Ref: SSD-73228210 (MOD 5)
Date: 7 April 2026

Re: SSD-73228510 (MOD5)
Property: 153 Parramatta Road, 53-75 Queens Road, Five Dock

Modification 5 seeks to allow signalisation of the Parramatta Road/William Street intersection (in-principle support from TfNSW), a new roundabout at the William Street/Spencer Street intersection, upgrades to the William Street/Queens Road intersection, additional traffic lane on the northbound side of William Street between Spencer Street and Queens Road, rearrangement of parking throughout the 4 basement levels for a total increase of 92 parking spaces.

Figure 3 Vehicle swept paths – northern loading dock

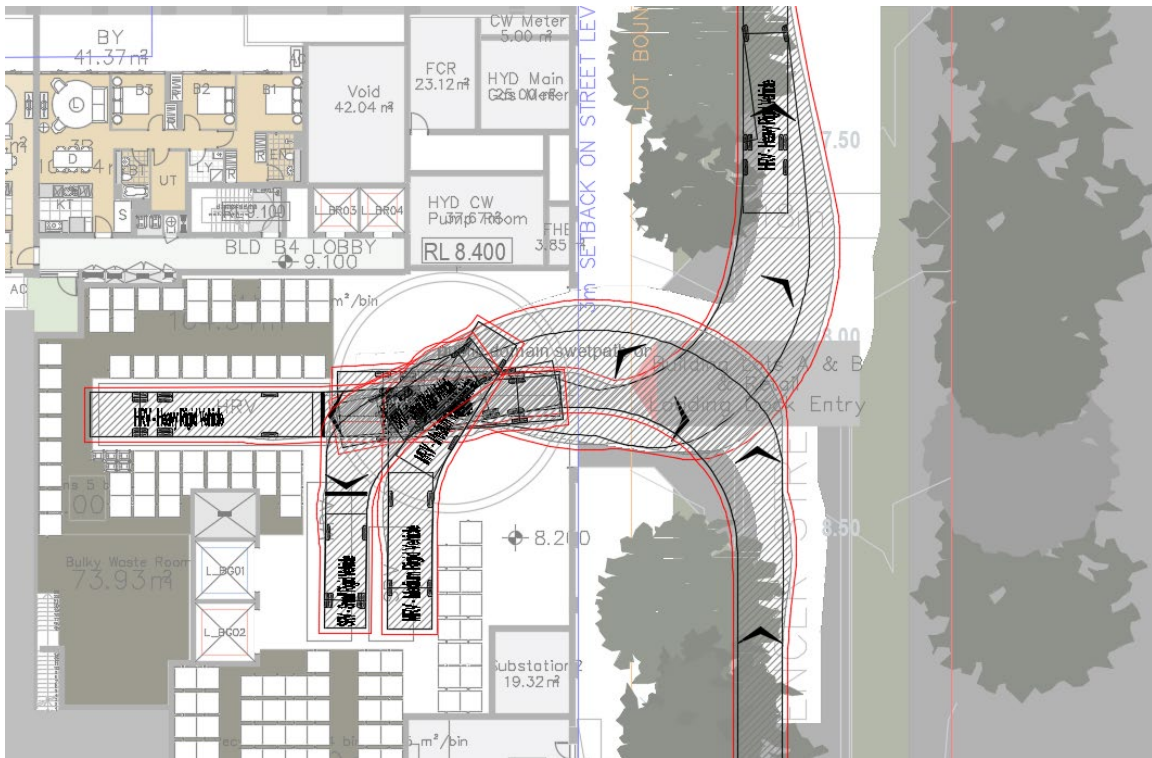
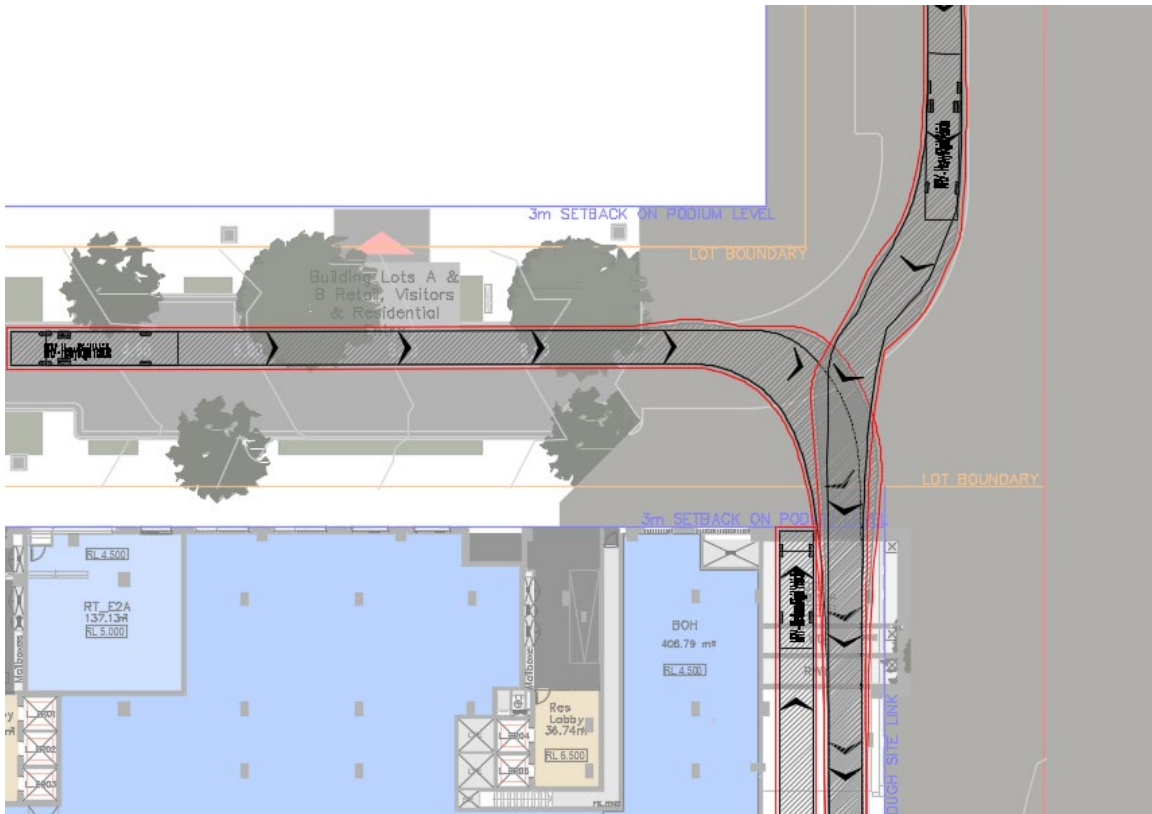
- Consent condition E43 (C) specifically restricts vehicles from travelling to the site during peak morning and afternoon periods whilst Consent condition F4 (C) specifically calls out that all loading and unloading operations associated with the site must be carried out in a manner so as not to cause inconvenience to the public or detrimentally impact the amenity of the locality.

- The Preliminary Loading Dock Management Plan proposes to operate for 24 hours a day, 7 days per week with reduced activity during peak school pick up/drop off periods (typically 8am-9am and 2:30pm-3:30pm). This appears to not comply with the aforementioned consent conditions restricting times of travel to the site.

- There are similar concerns where the proposed 24 hour operation will encourage heavy vehicle movements during the night between 12am-5am, thereby impacting the amenity of the locality and future residents.
